Please ask for: Mrs D Johnson
Email: daun.johnson@arun.gov.uk
Telephone: 01903 737762
Our Ref: A/193/20/PL
Your Ref:
Date: 7th December 2020

Application for Planning Permission

Development: Erection of a 1 No. 3 bedroom chalet bungalow & detached garage. This site is in CiL Zone 3 and is CIL Liable as dwelling.
Location: Ham Manor Cottage Ham Manor Way Angmering BN16 4JQ

Revision:	A	Dec 2020	Dimension added
address	Ham Manor Cottage, Ham Manor Way, Worthing, West Sussex		
project	Proposed construction of 3 bedroom detached property with detached double garage		
title	Proposed Block Plan		
scale	date	dwg no.	revision
1:200 on A4		2020.275.02	A

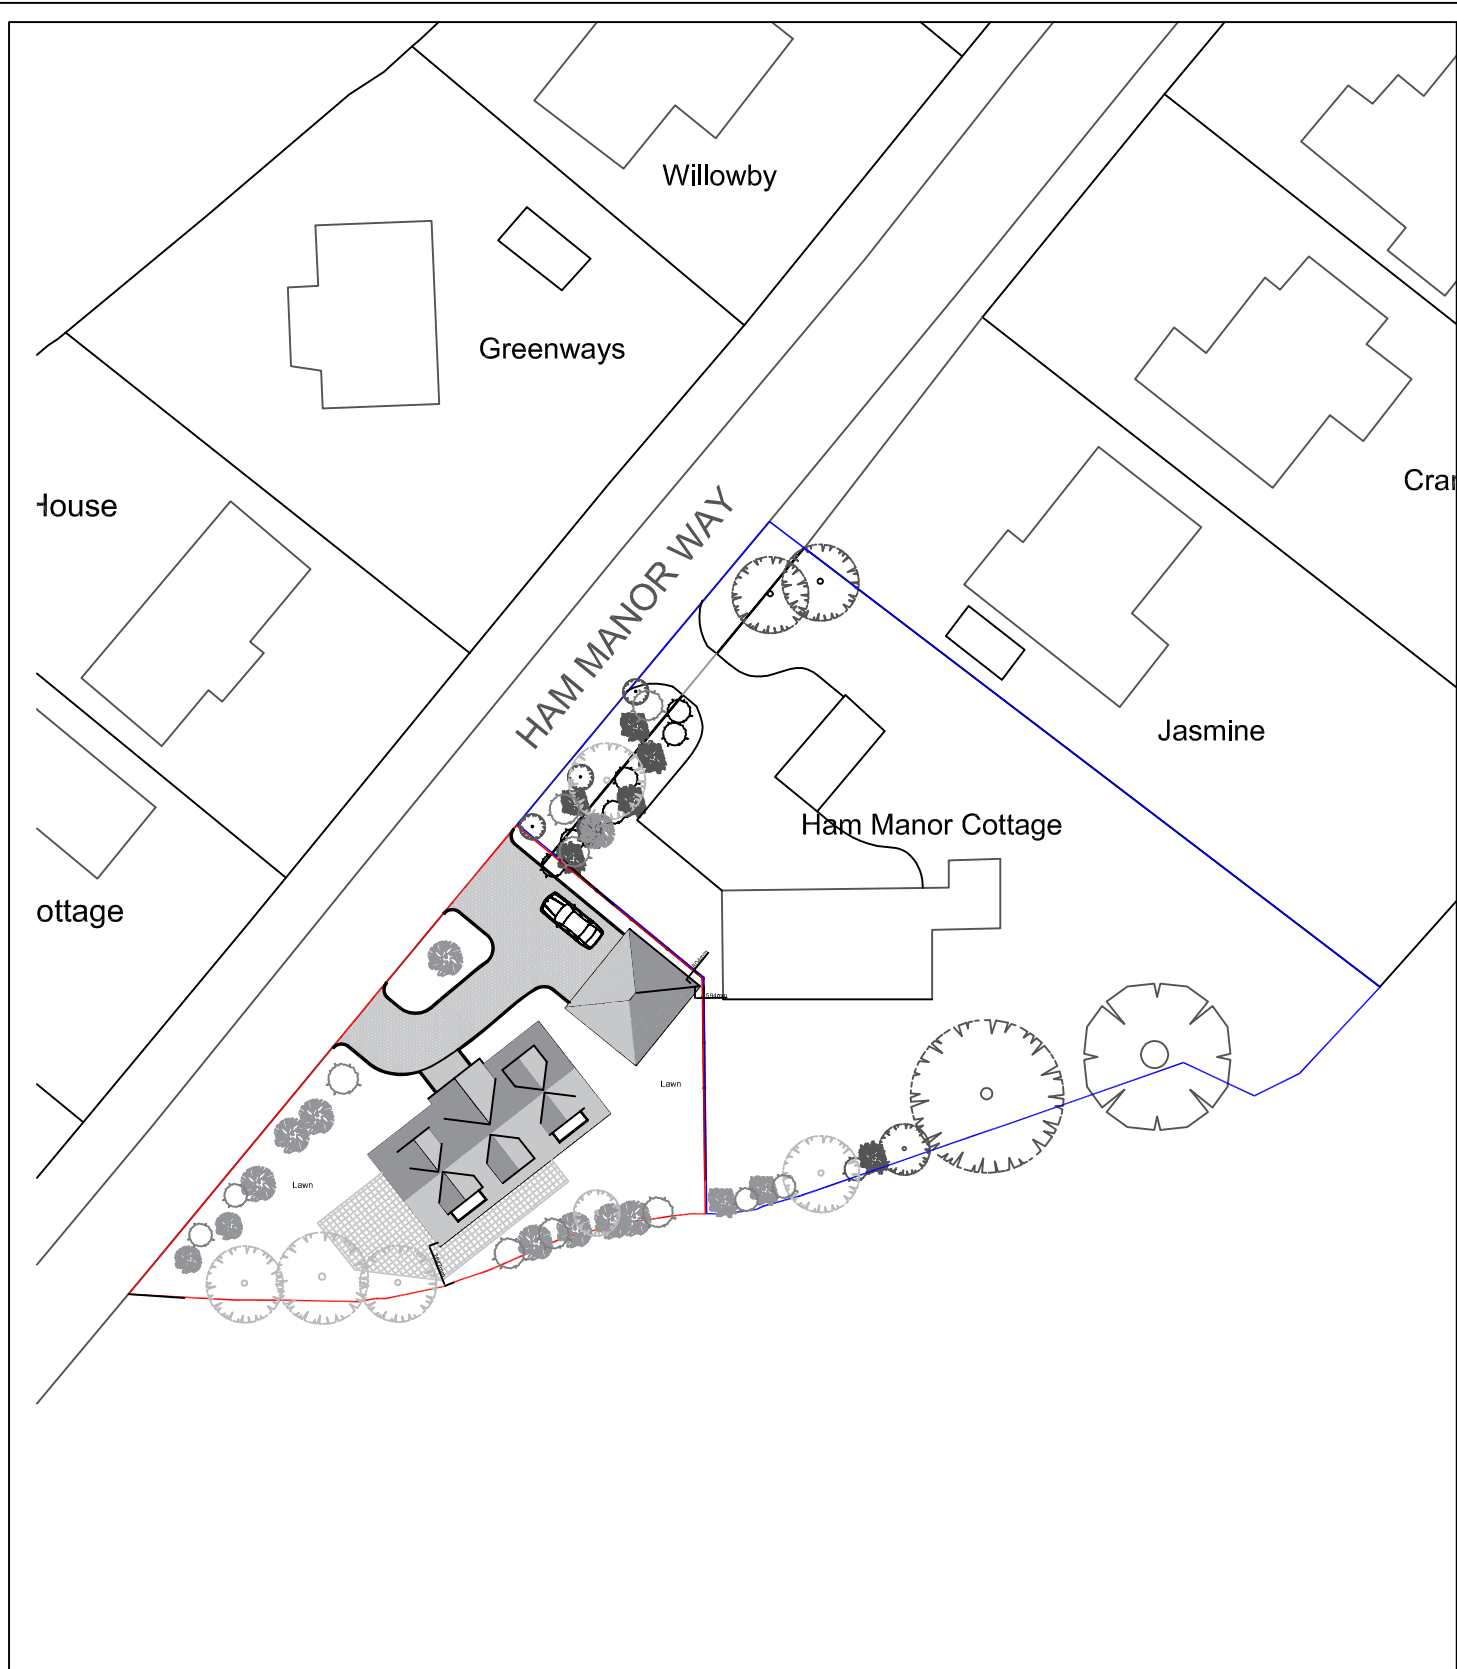
On the proposed block plan, please provide measurements from the proposed dwelling and garage to the site boundaries.
